Feasibility Report

**Conversion of Grade II Listed Office Building back to
a Dwelling**

Headmasters Hall,

The Square, Pennington

Project: Headmasters Hall, Wainsford Road
Drawing: Proposed First Floor Plan
Drawing No: 2020_PP-014
Scale: 1:50 @A3
Date: March 2021

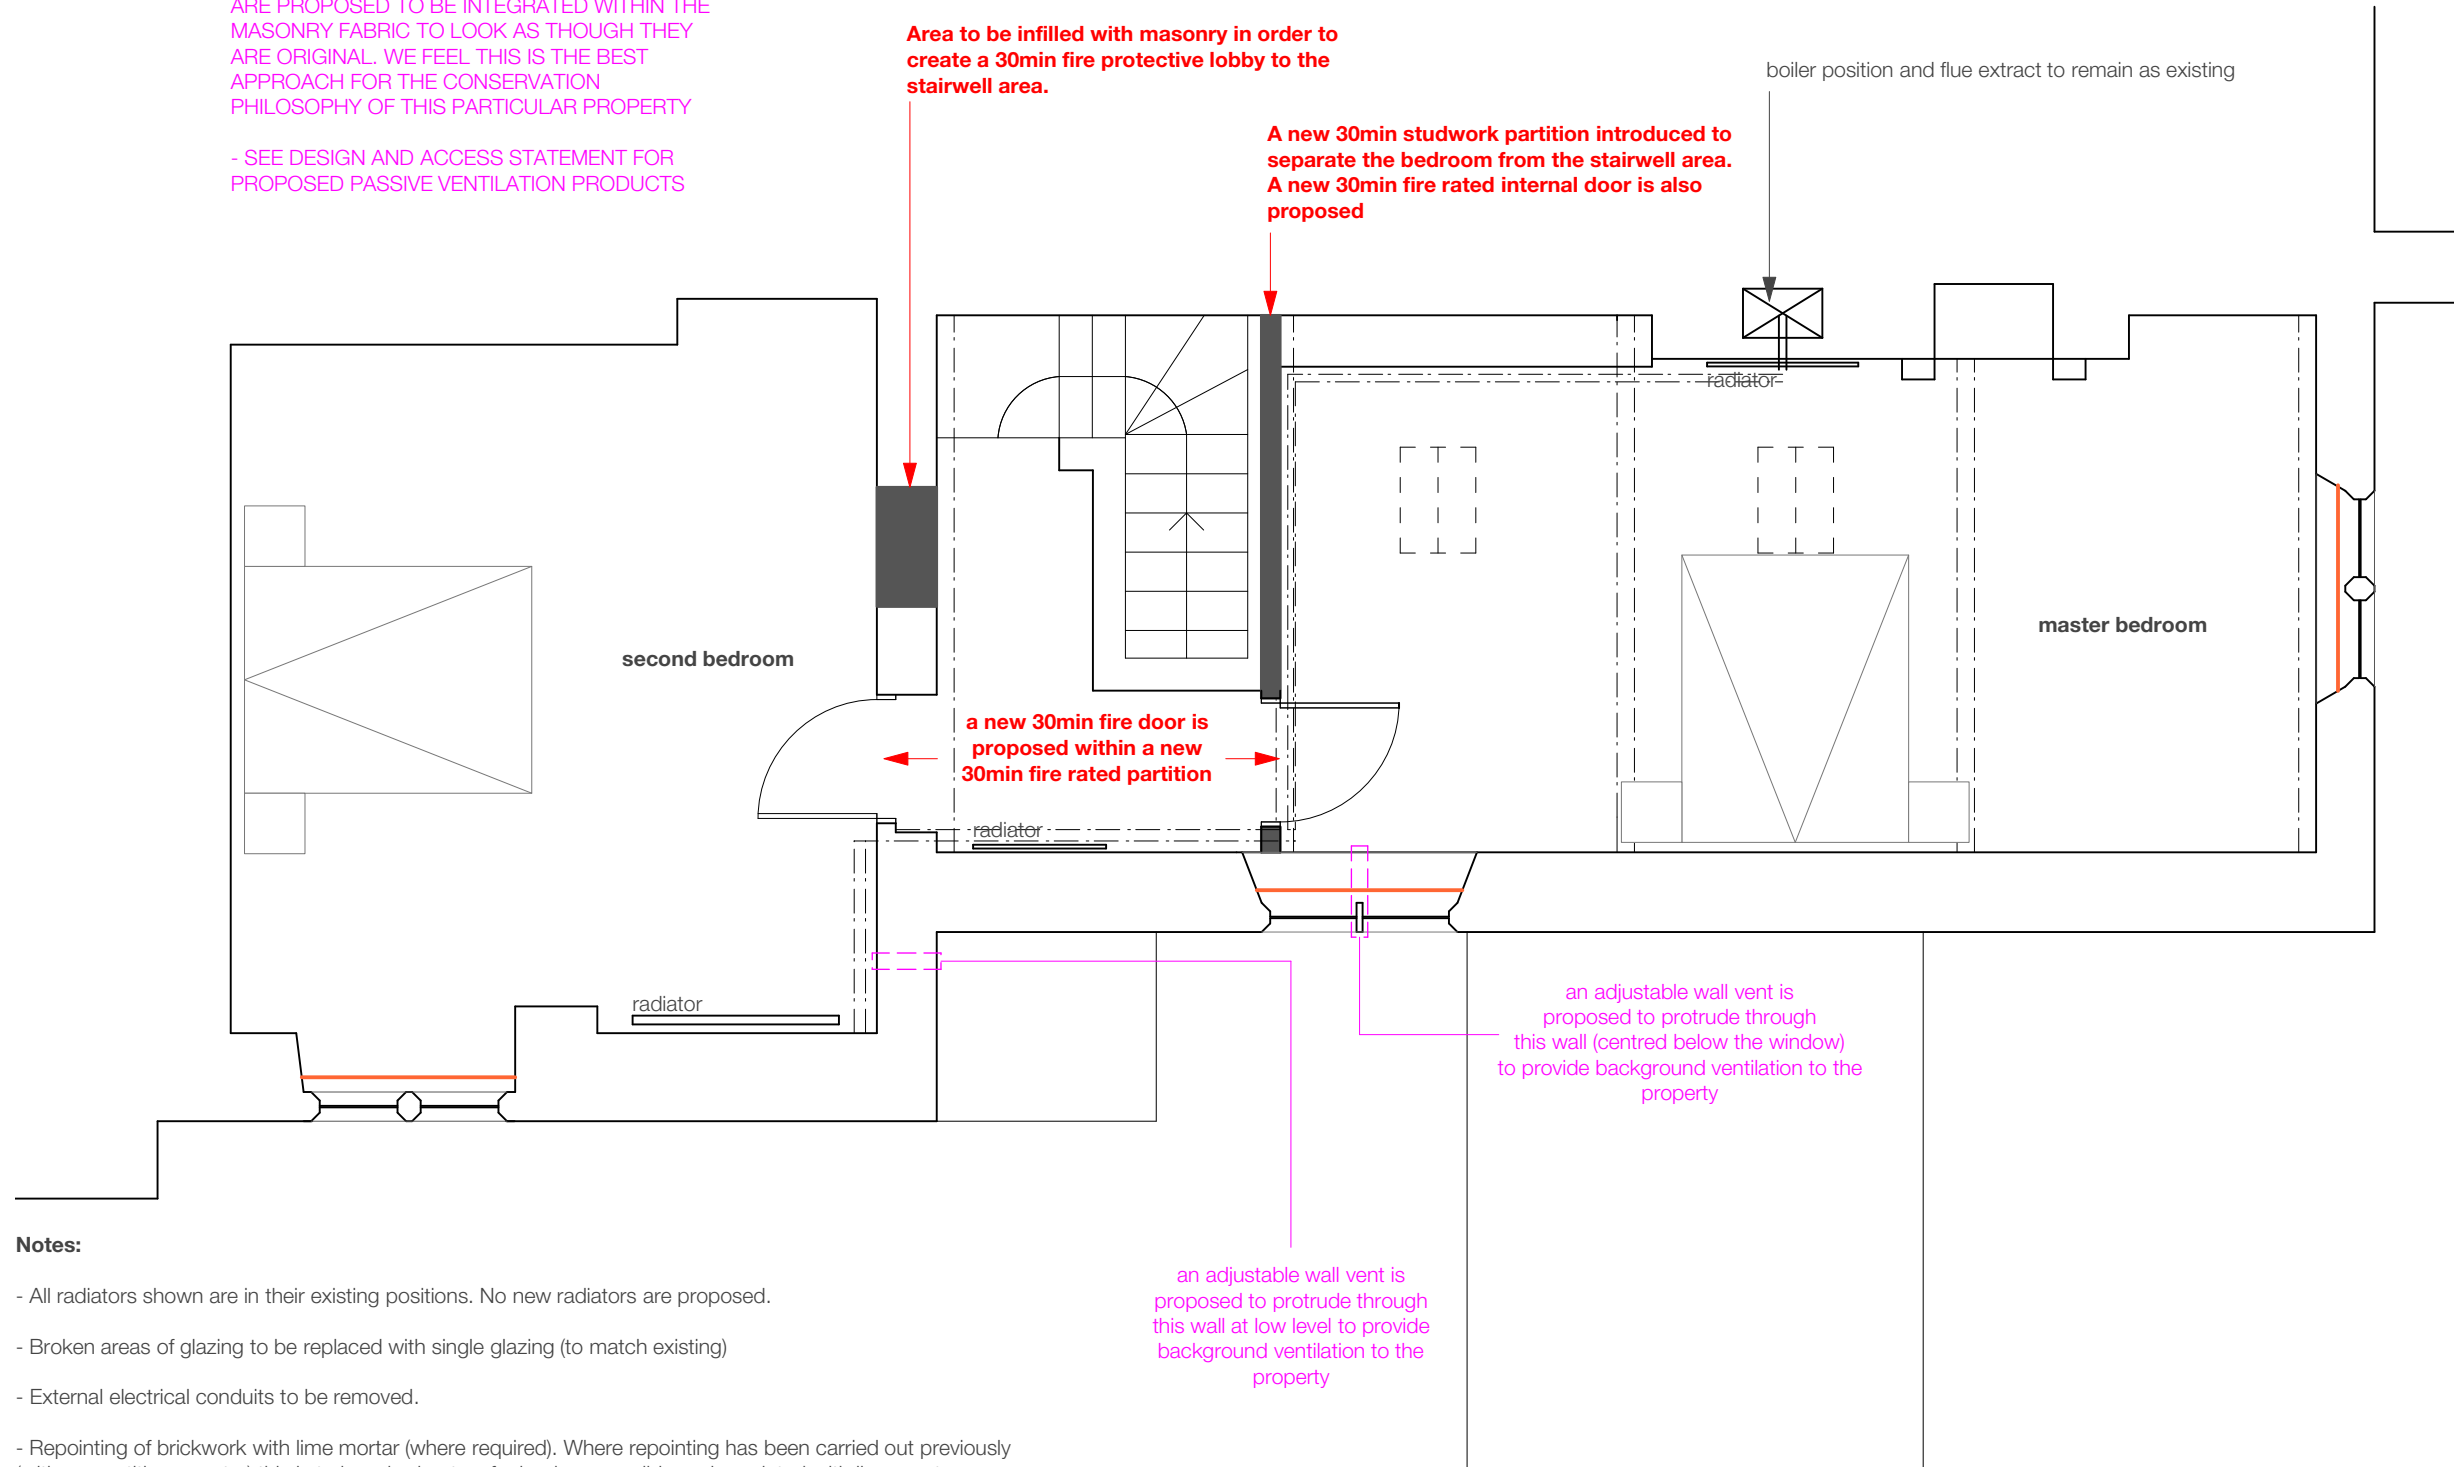
Internally some alterations are proposed to remove some of the existing walls. One wall has been classified as modern on the proposed plans, but what of the other walls proposed to be removed within the proposed living room and kitchen? Are the existing doors modern or historic and what is the proposal for them? Is there an opening to be blocked within the bedroom on the first floor?

We are not proposing to remove any of the original walls/partitions. We are proposing to remove a glazed partition that was introduced to the building in more recent years, which can be

seen on page 17 but this can also be appreciated if the Conservation Officer visits the building. Other areas we propose to alter are one existing doorway, which we are looking to block up and new internal stud work partitions, on the upper floor, which are designed to achieve a 30min fire rating (in order for a fire lobby to be created around the existing stairwell area).
